KITTITAS COUNTY COMMUNITY DEVELOPMENT SERVICES

Subject: Wenger (SPF-18-00005) Final Short Plat – Staff Review and 2nd Request for Additional Information

**WENGER SHORT PLAT - SP-07-00007**  
**A PORTION OF THE E 1/2 OF THE NE 1/4 OF SECTION 29,**  
**TOWNSHIP 20 NORTH, RANGE 14 EAST, W.M.,**  
**KITTITAS COUNTY, WASHINGTON**

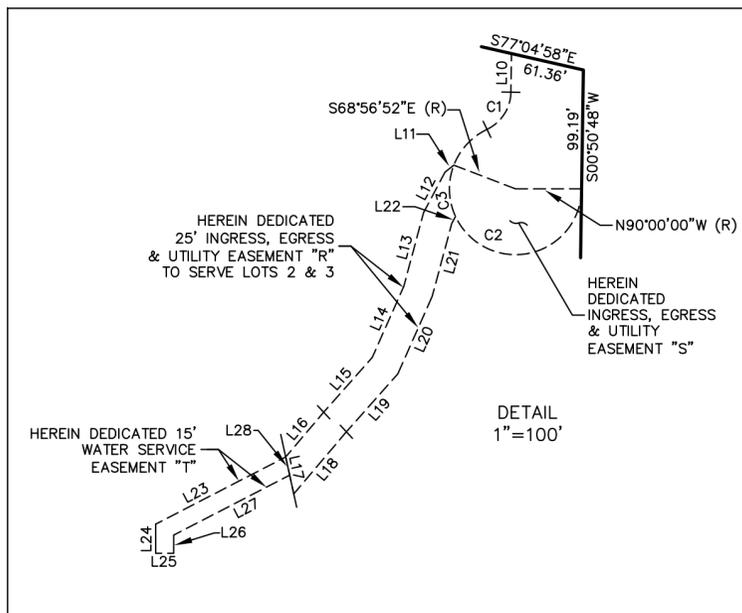
- 1) Condition of approval 7(d)(v) requires that the easement and driveway be shown serving parcel 616536. As submitted, the plat does not clearly depict access to parcel # 616536. There is an easement shown crossing the Wenger property, however, the easement is not labeled demonstrating it is for parcel # 616536. Please update either the plat note # 14 or the actual easement to indicate what parcel it serves.

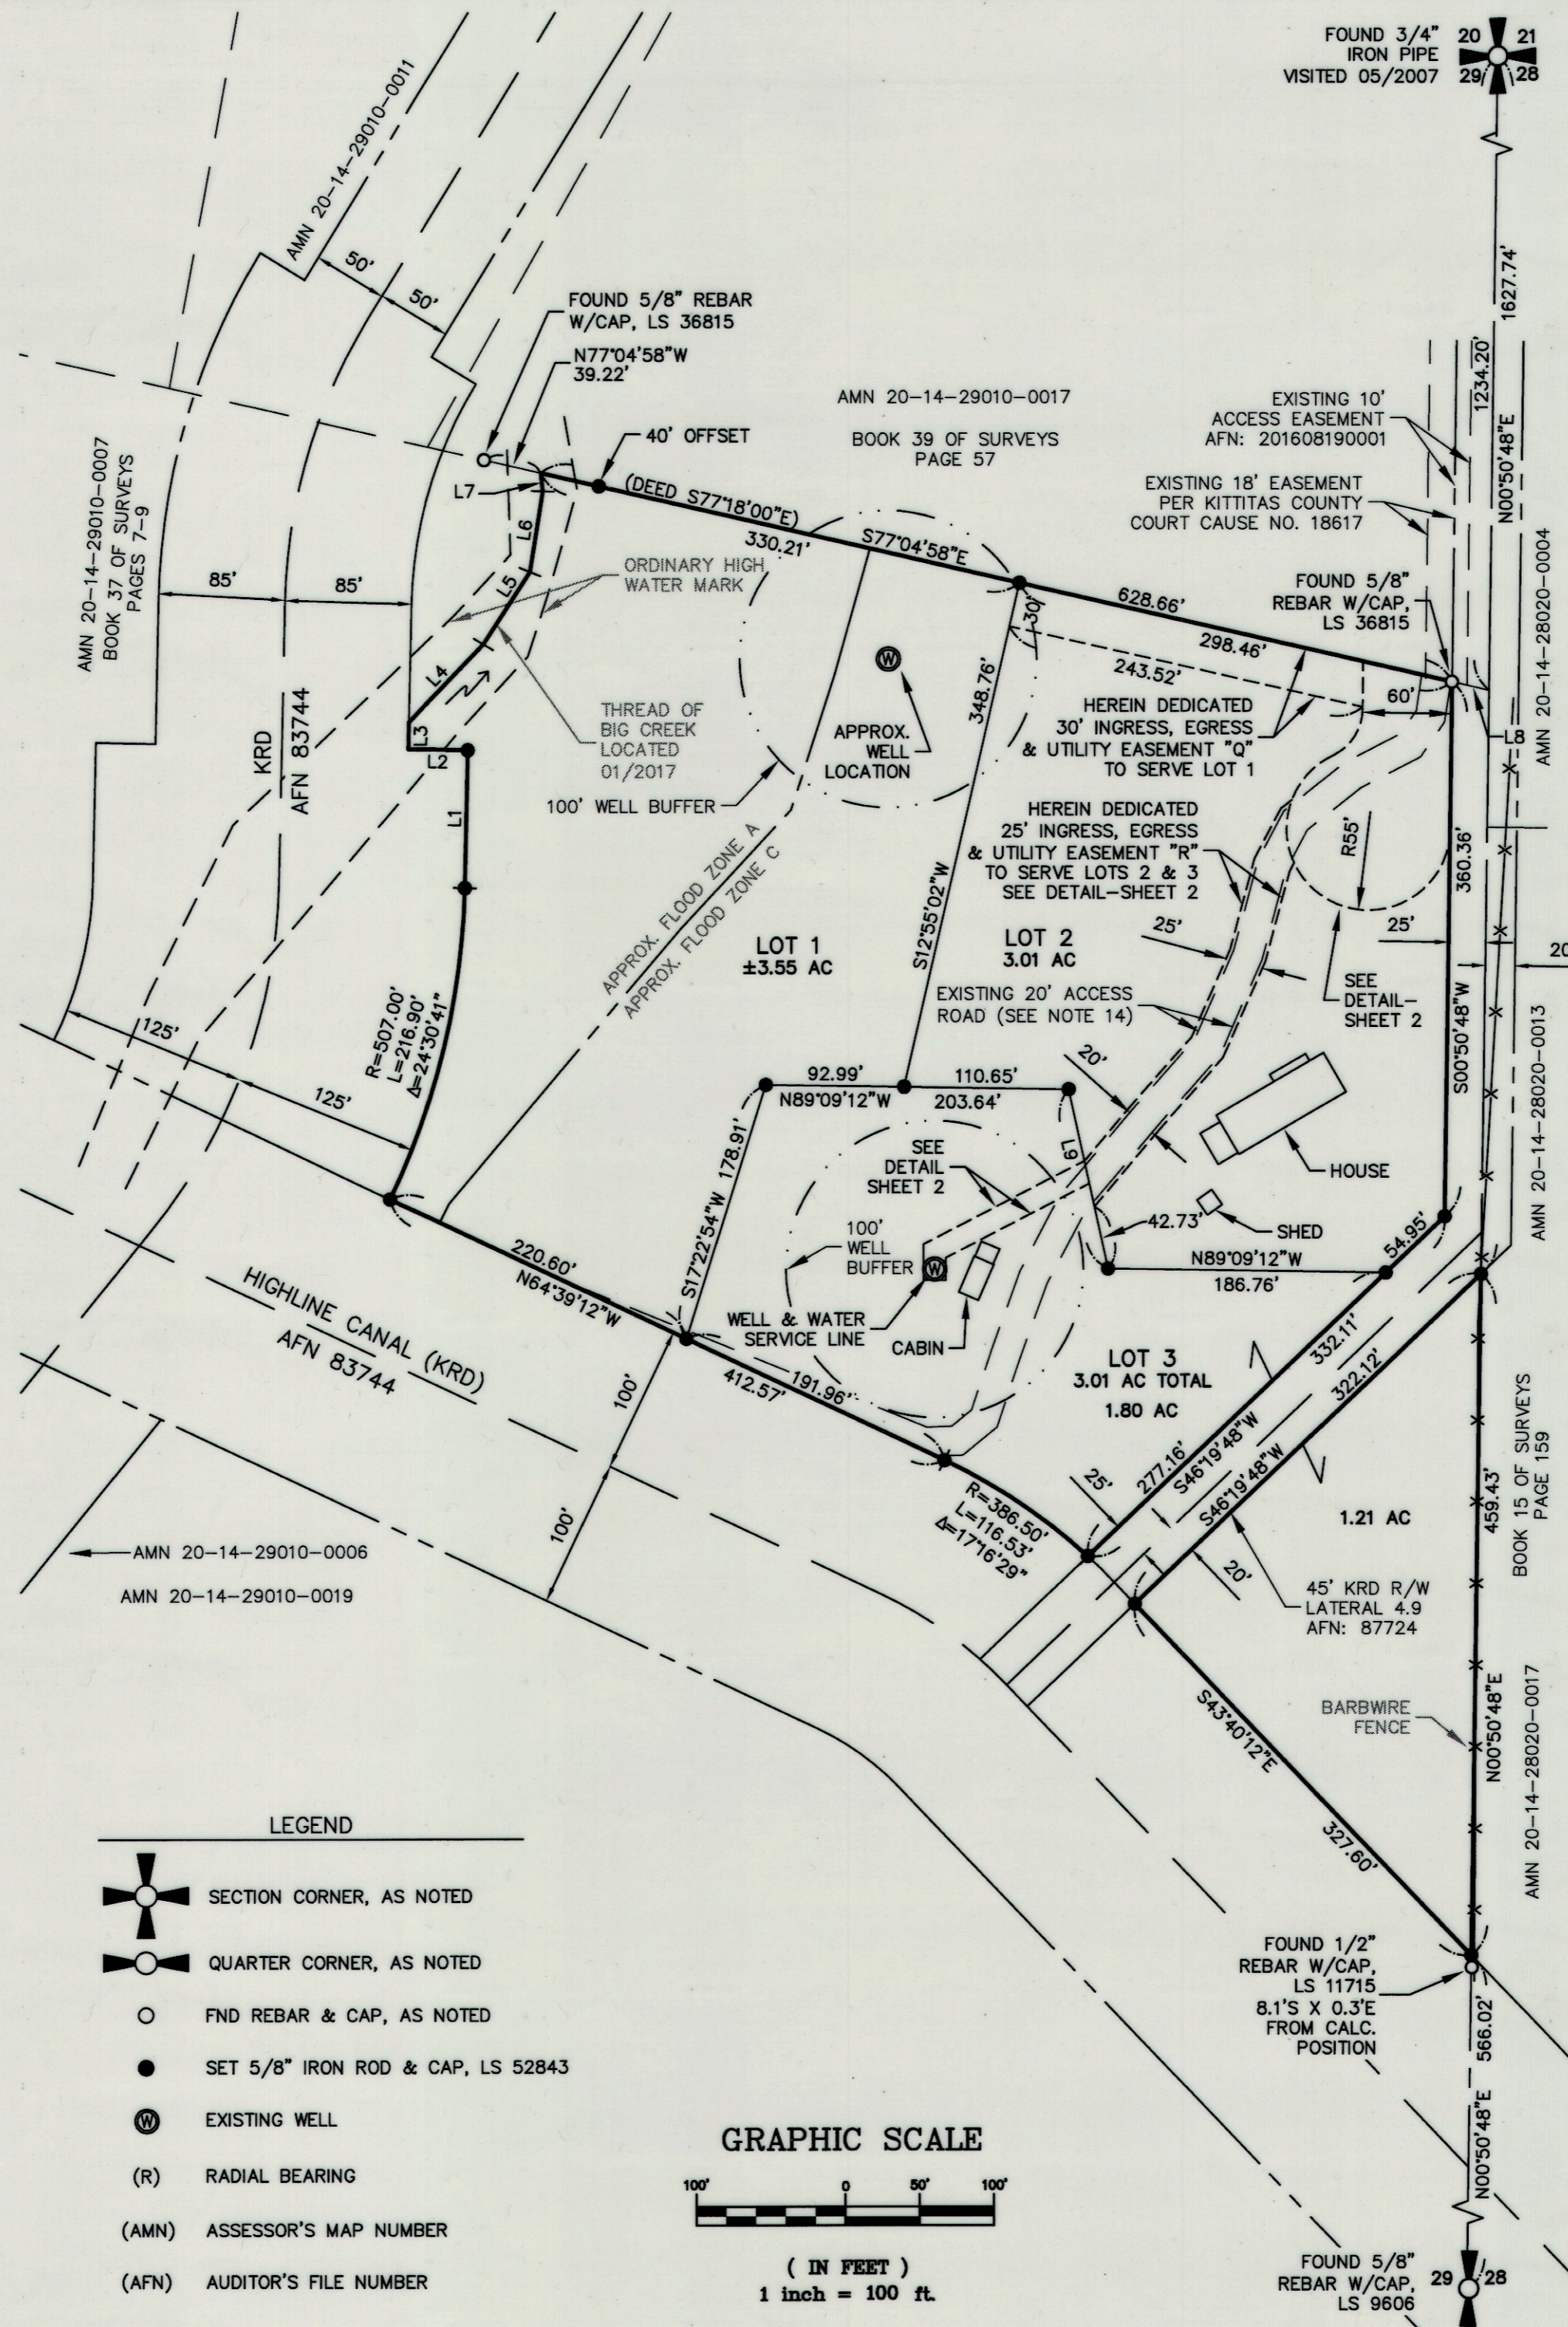
- 1) The shoreline jurisdiction has not been indicated on the face of the plat. If the 100 year floodplain and the 200' shoreline jurisdiction boundary are at the same line, it needs to be clearly labeled as such on the final plat, pursuant to condition 7(d)(ii) of the conditional approval for the Wenger Short Plat.
